**Re: PA22-023- Brodie Rezone PRD – Technical Review 1**

RE: Brodie Subdivision, File# PA22-023  
45 lot subdivision with potential zoning change  
8703 60<sup>th</sup> ST NE & Parcel # 30052500303900; 30052500303800; 30052500302300

LAND PRO GROUP, INC.
BRODIE PLAT
 PRELIMINARY SITE PLAN

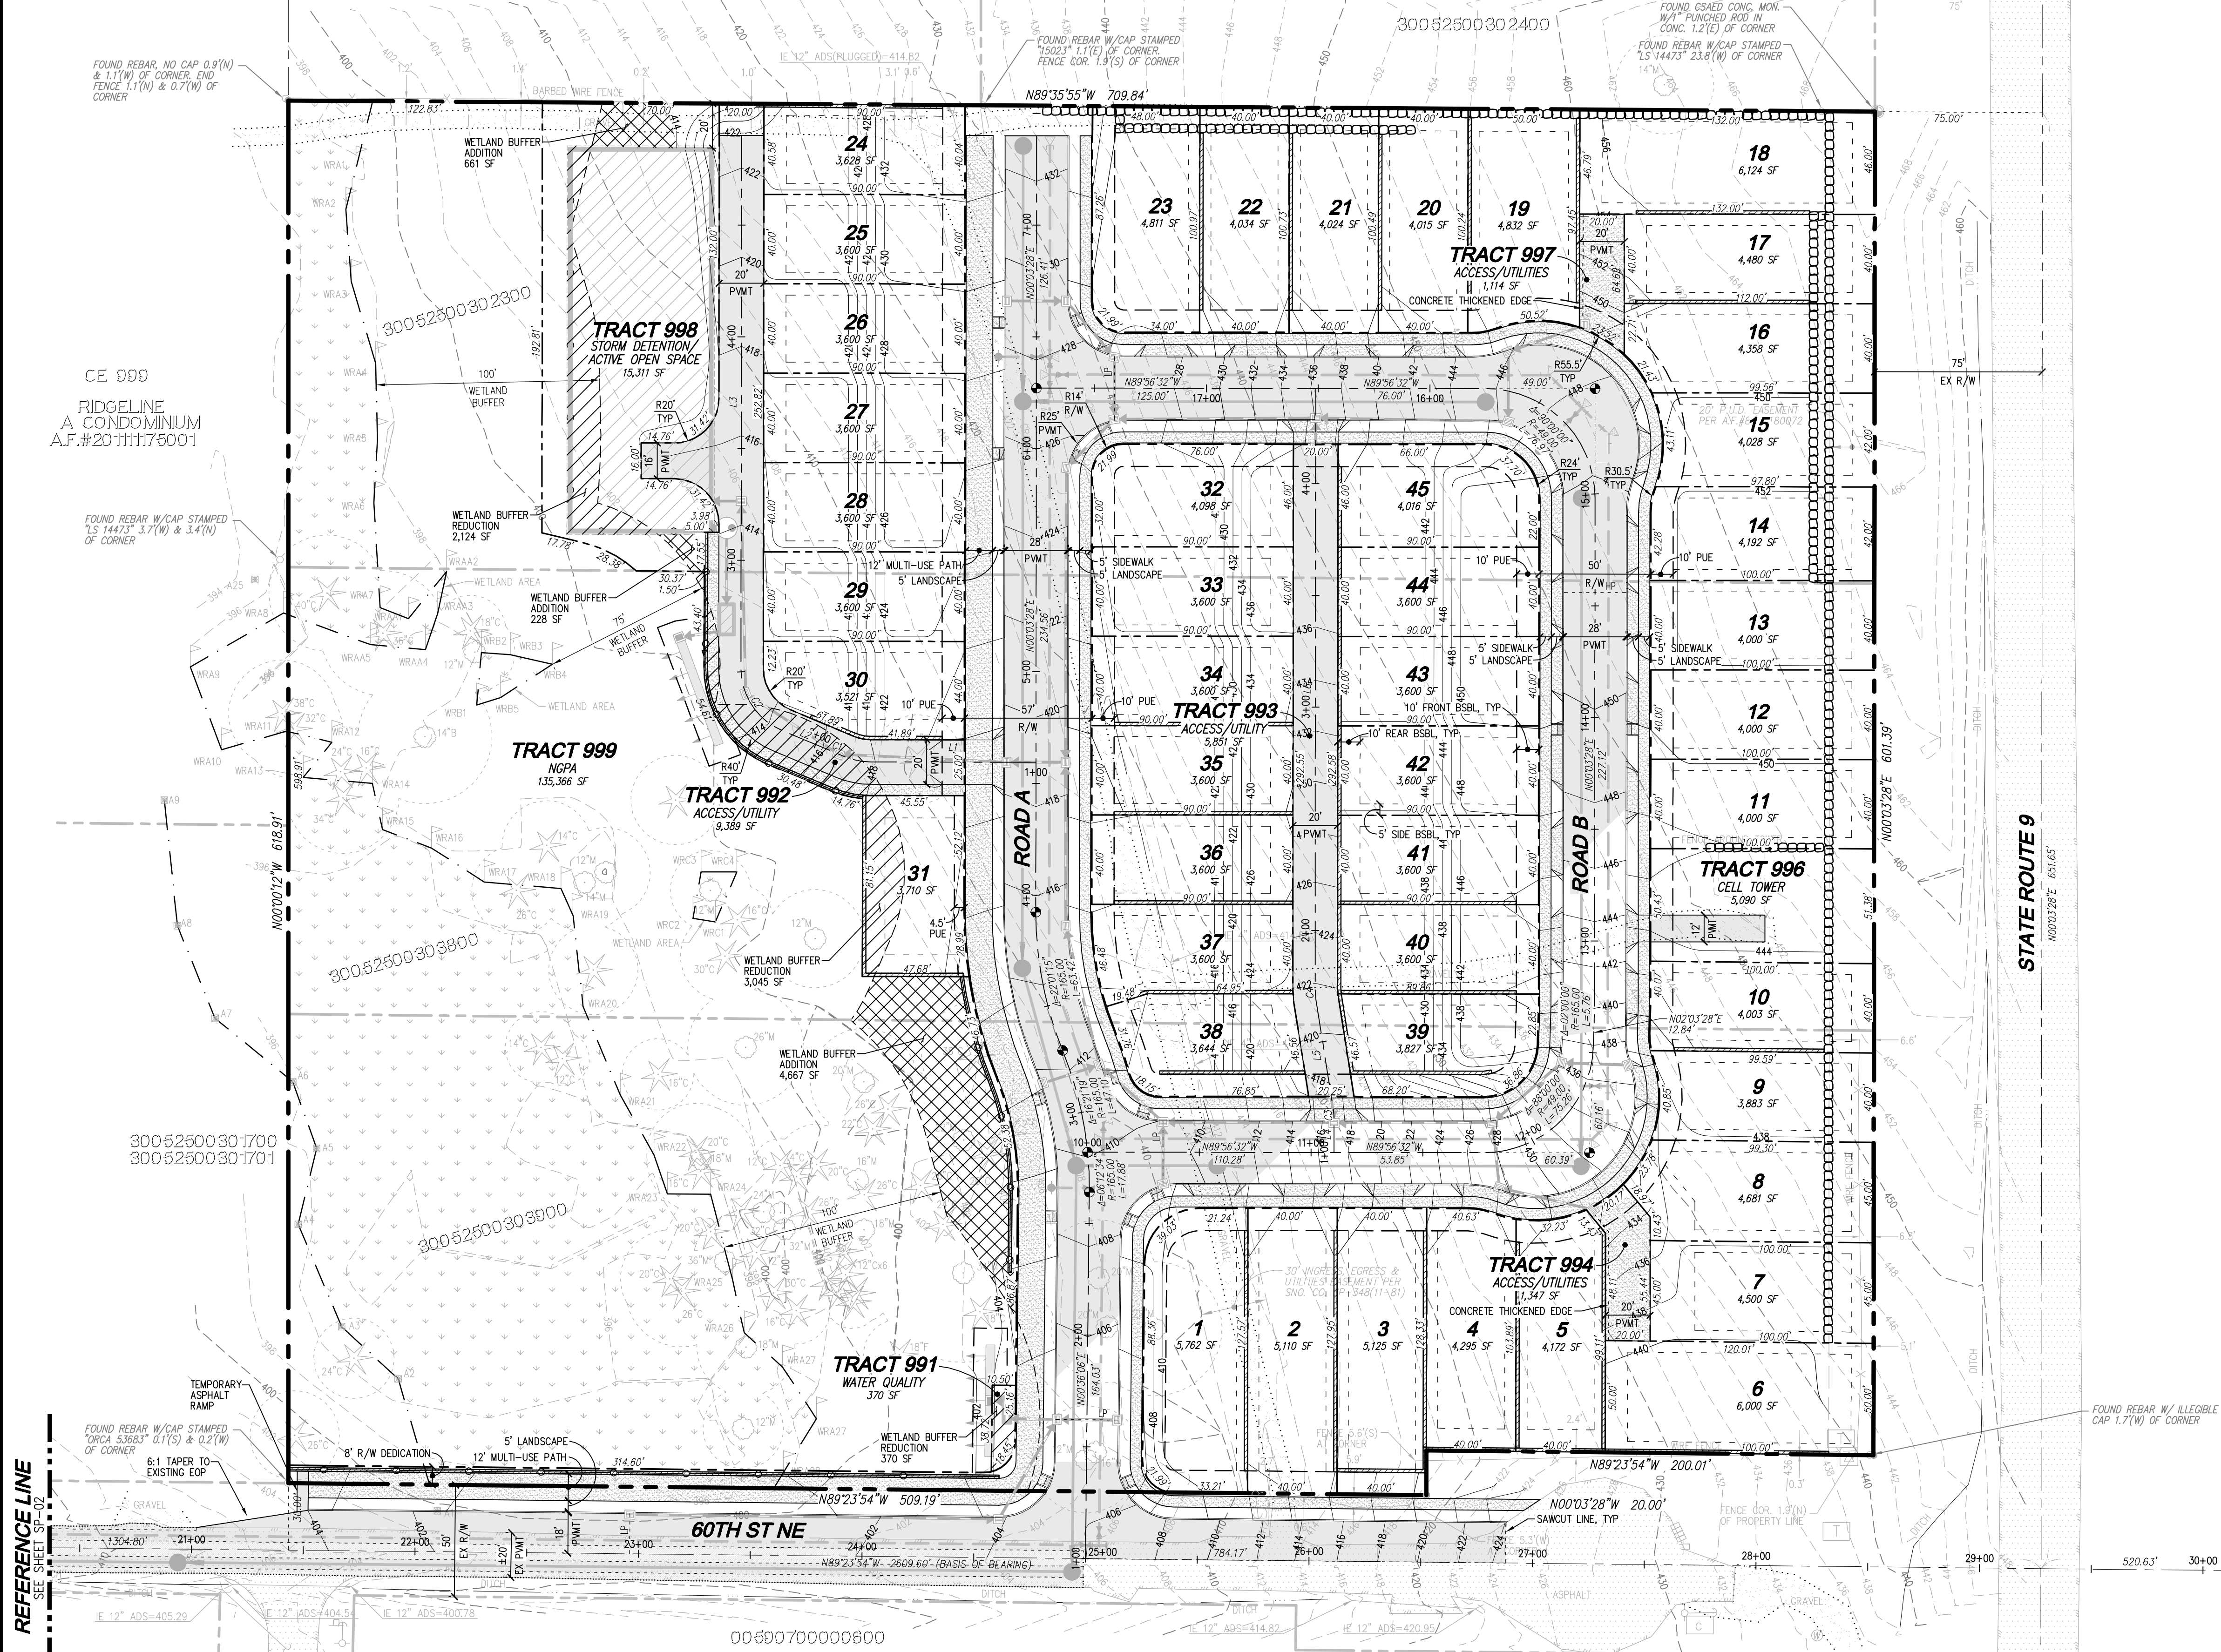
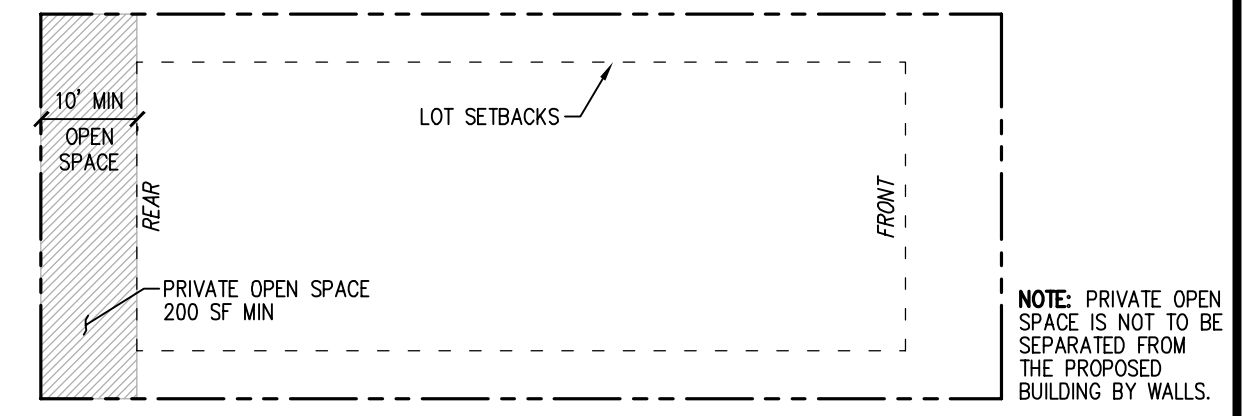
1. Include File Number PA22-023 on all future correspondence, in addition to all site, civil and landscape plans.
2. The proposed lot and tract configurations on **sheet CS-01 and sheet CS-04 of the site plan** do not match.
3. On **sheet CS-01 of the site plan**, the below figures are provided. However, these totals do not match the wetland buffer reductions and additions figures provided in the supplemental Critical Area Study and Buffer Mitigation Plan. Revise figures accordingly.

4. To aid in quick reference and review, provide a table within the site plan that includes details for Tracts 990 – 999, including tract size and proposed use.

10. Tract 998 proposes to include a portion of the proposed wetland buffer addition. This 644 sq. ft. buffer addition area will need to be relocated outside of the tract and not north of the proposal vault. Suggest moving the vault further north and incorporating the required buffer addition, south of Tract 998. Critical areas and their buffers must be incorporated into separate tracts; revise plans to remove that area from Tract 998 and include this buffer addition into Tract 999.

11. The provided plans appear to include proposed landscaped areas into the active open space area calculation of Tract 998; revise calculations to exclude the proposed Tract 998 buffer landscaping from the dedicated active open space area.

PROPOSED INTERNAL 50' ROW PRD ROAD SECTION (PARKING LOCATION VARIES)

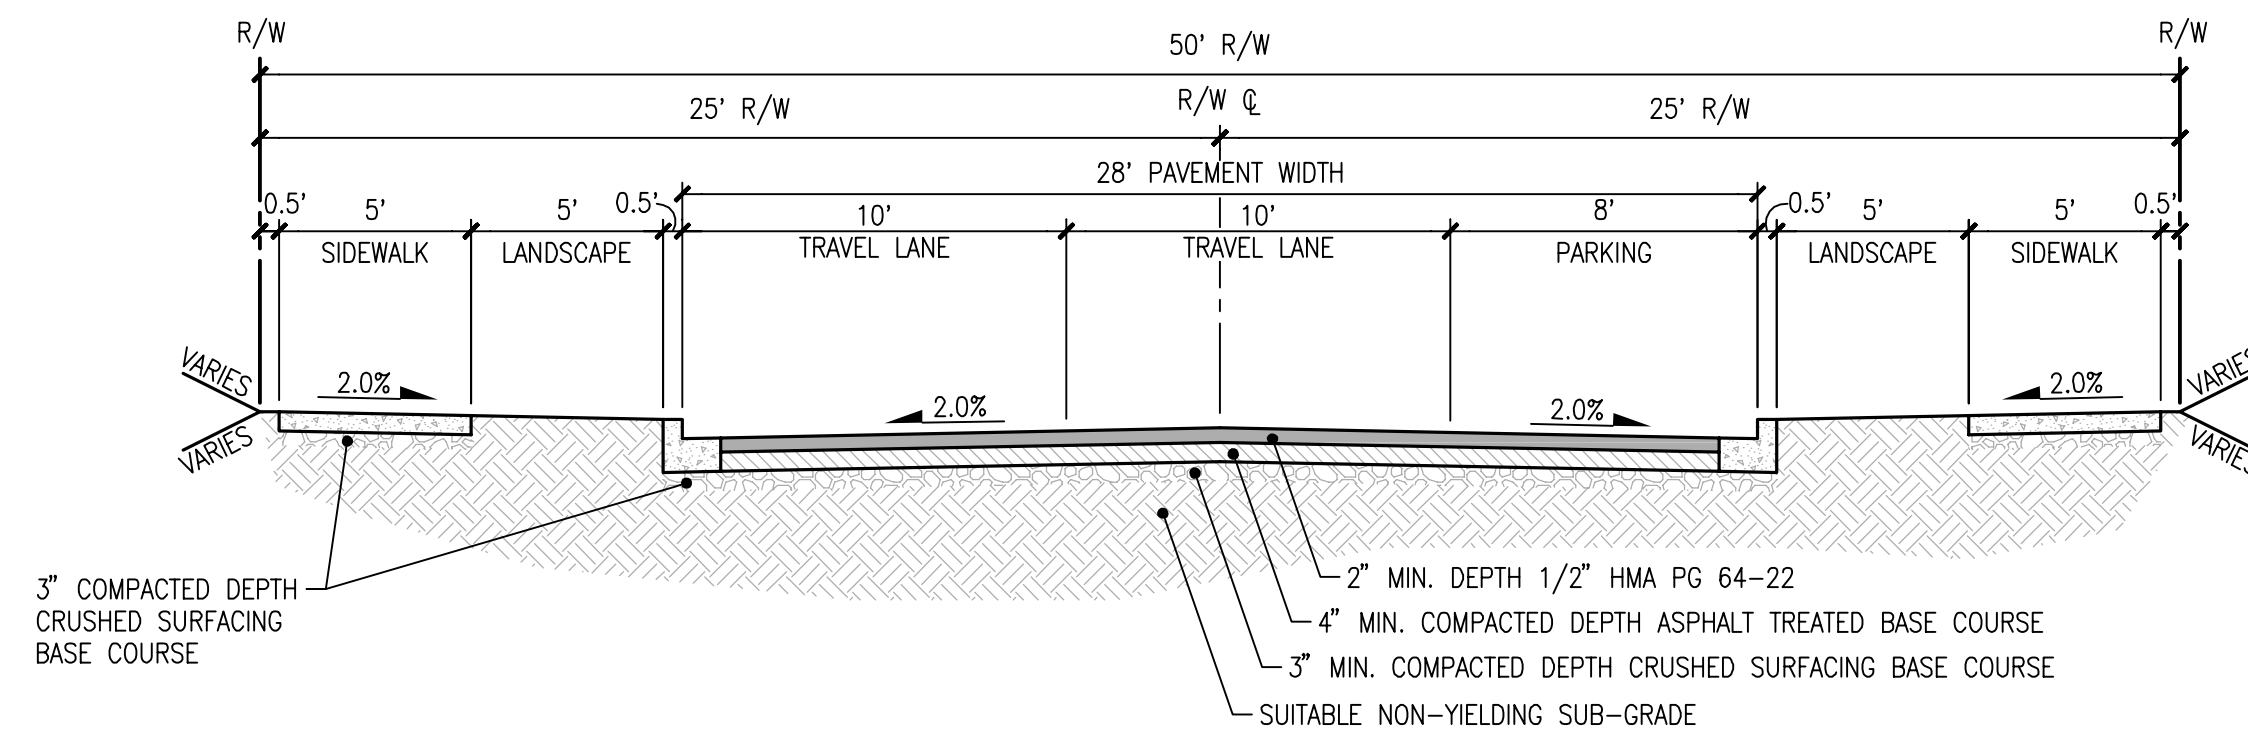
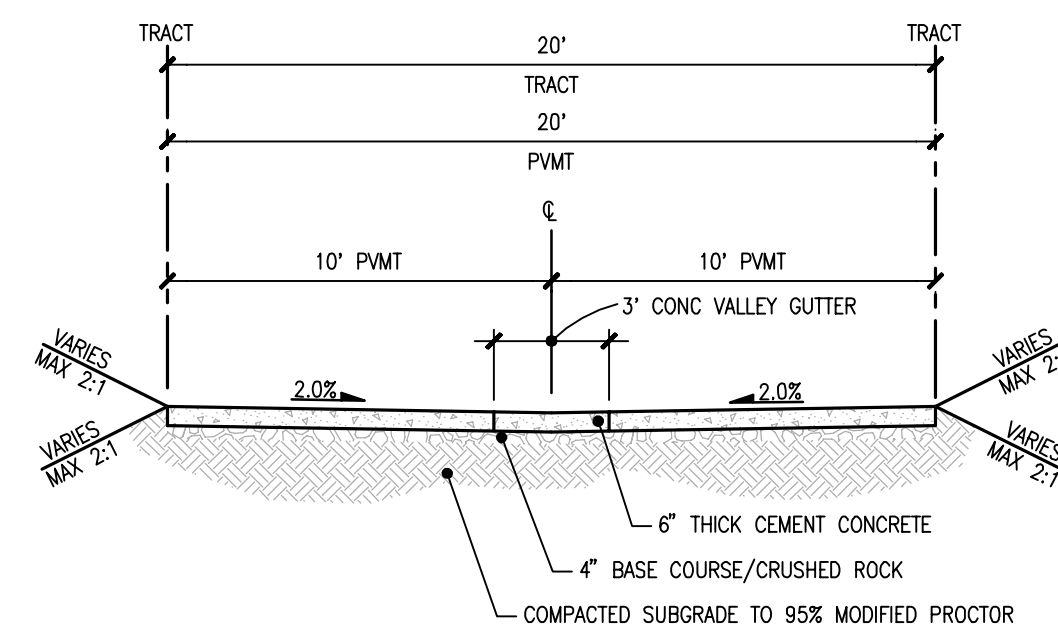
- b. Internal Residential Roads:
    - i. Road Cross-section:
      1. Remove dimensions showing parking on one side and instead dimension to indicate 14' to center from each curb.

- d. The new roads shall be constructed to SP 3-201-006.
  - e. *The proposed alley (TRACT 993) needs to have a 20' radius.*
  - f. *If TRACT 992 is proposed for lot access it does not meet the design standard intended for an auto court as it serves more than 6 lots. This tract also does not qualify as an alley since it terminates at a dead end.*

LAND PRO GROUP, INC.
BRODIE PLAT
 PRELIMINARY COMBINED UTILITY PLAN

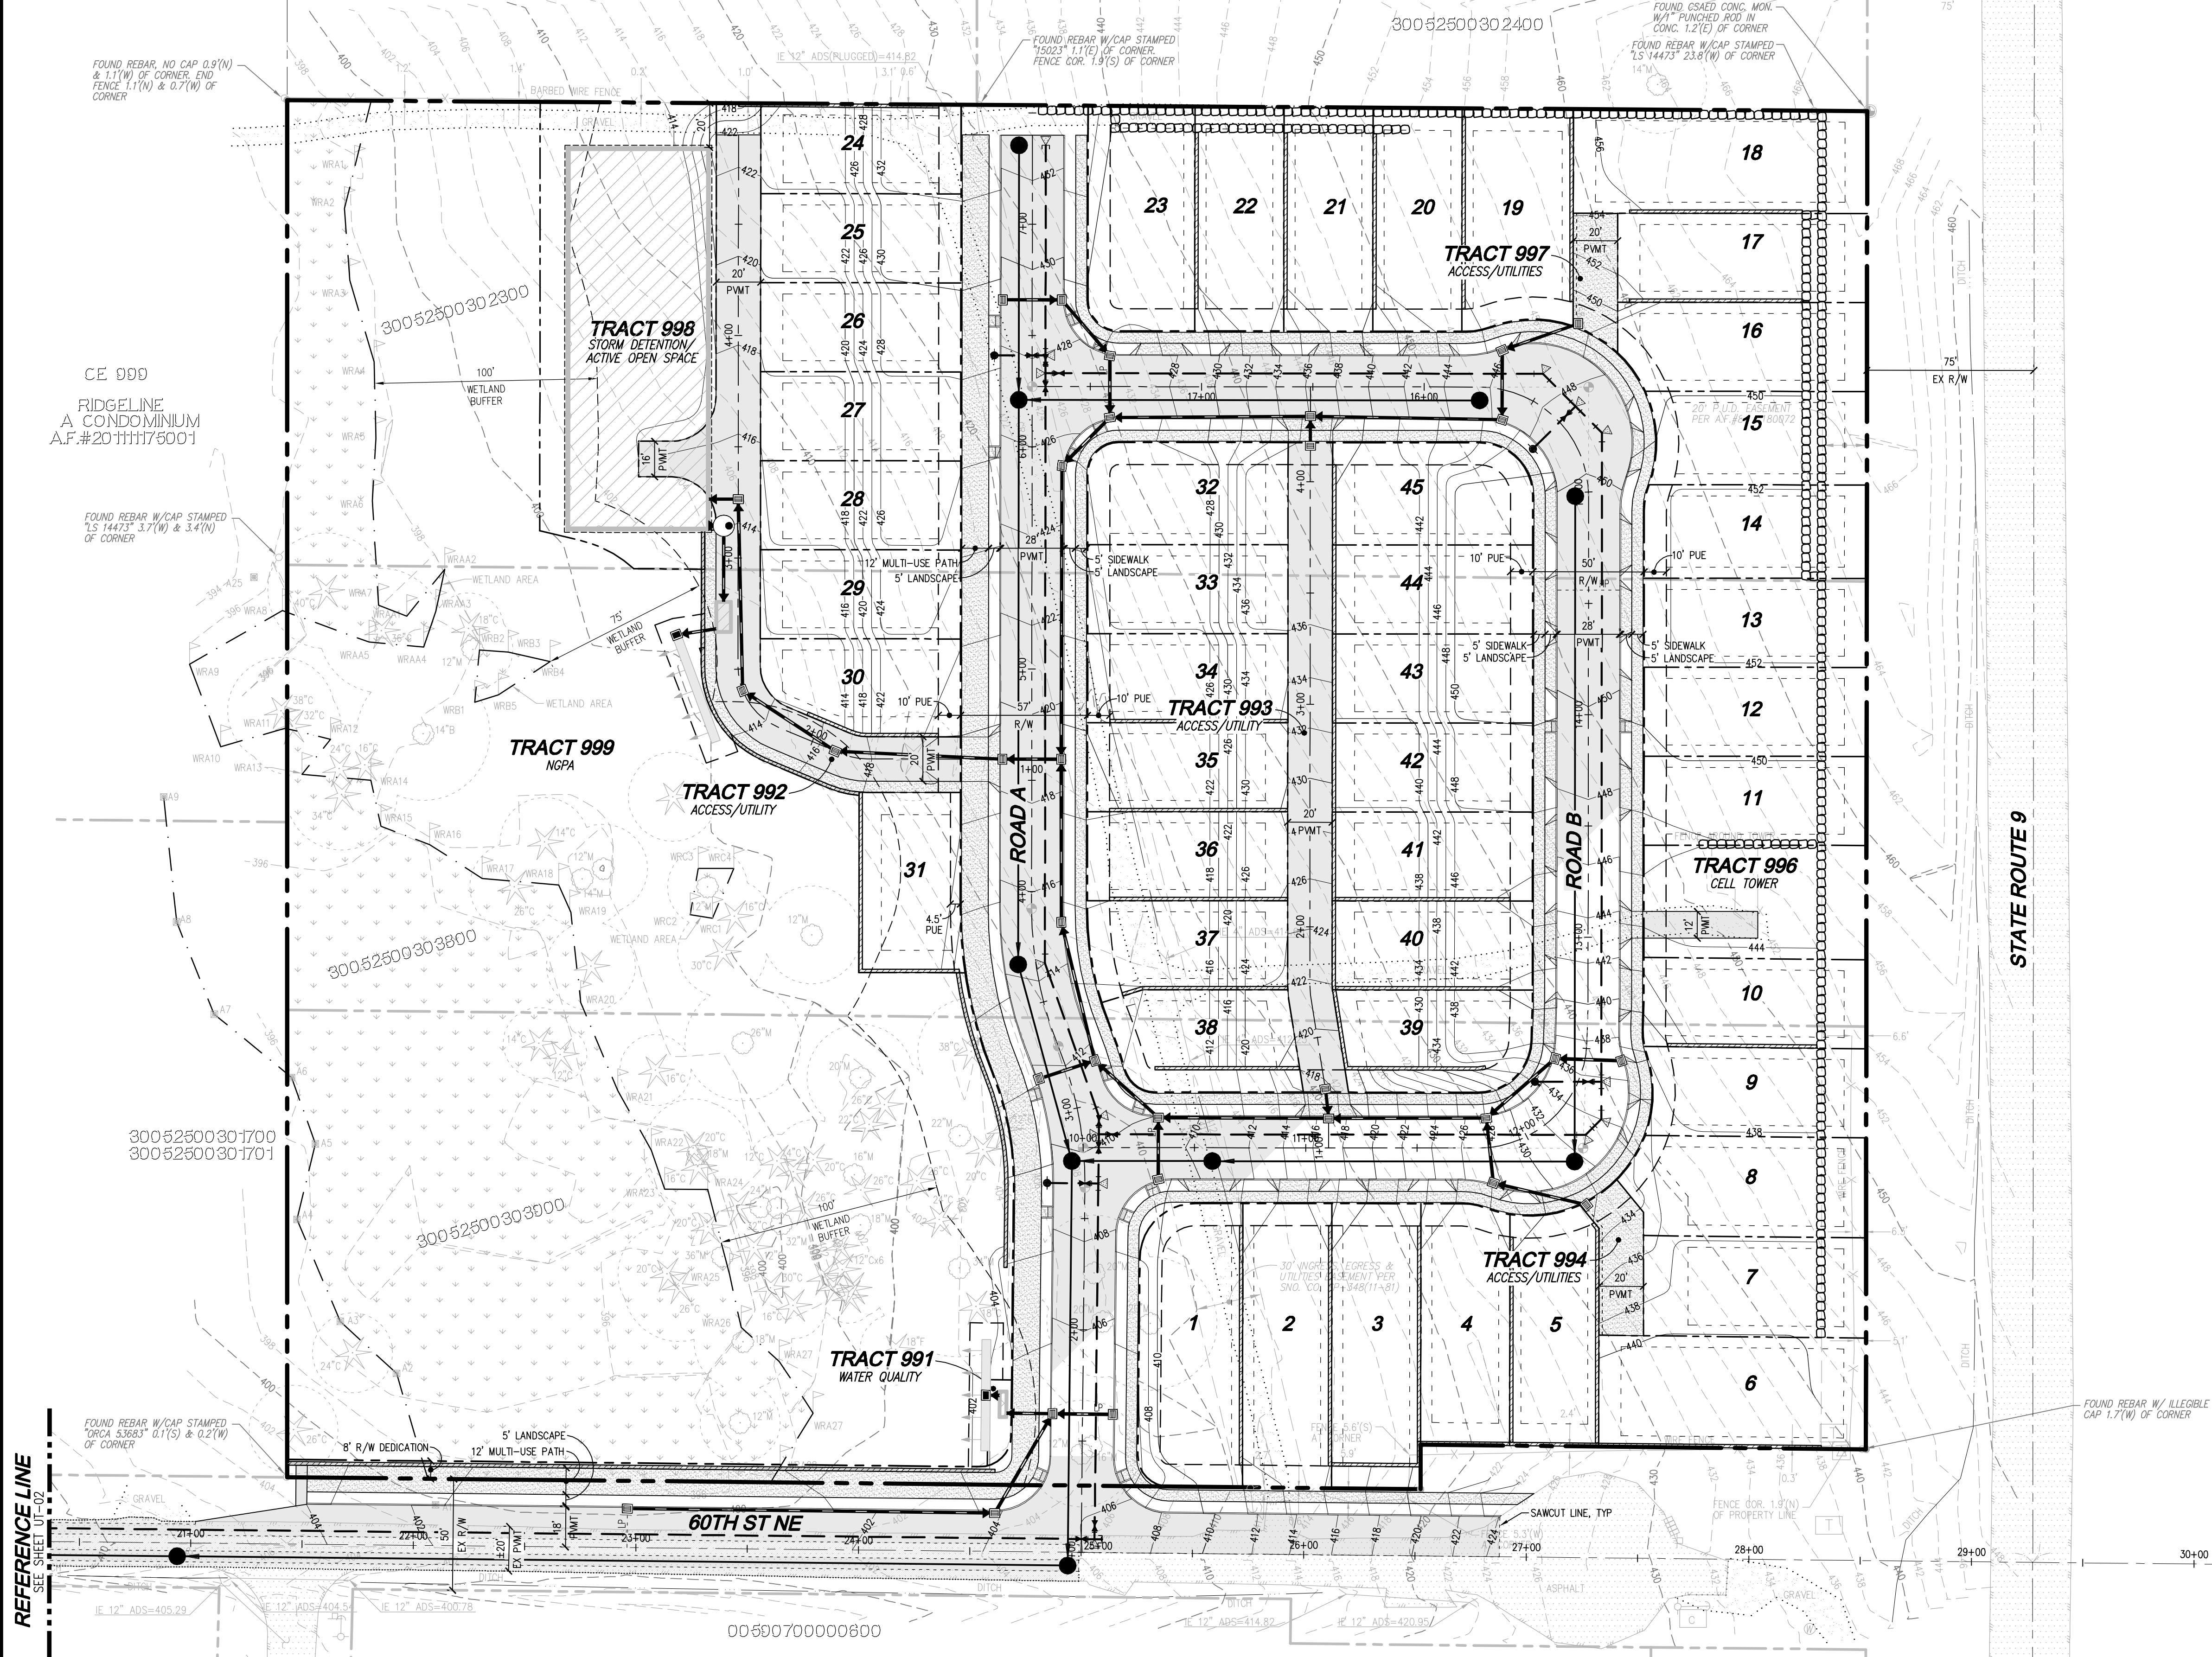
1. Water meters are not shown on plans;
2. Water details not shown;
3. Size of water main not called out on plans;
4. Plans show water main connecting to 83<sup>rd</sup> Ave NE. Connection needs to be to 16" water main on 87<sup>th</sup> Ave NE with 12" water main, continue 12" water main east on 60th St NE then along Road A to end. A hydrant assembly will be needed at the end of Road A;
5. The looping water main within the development can be 8".
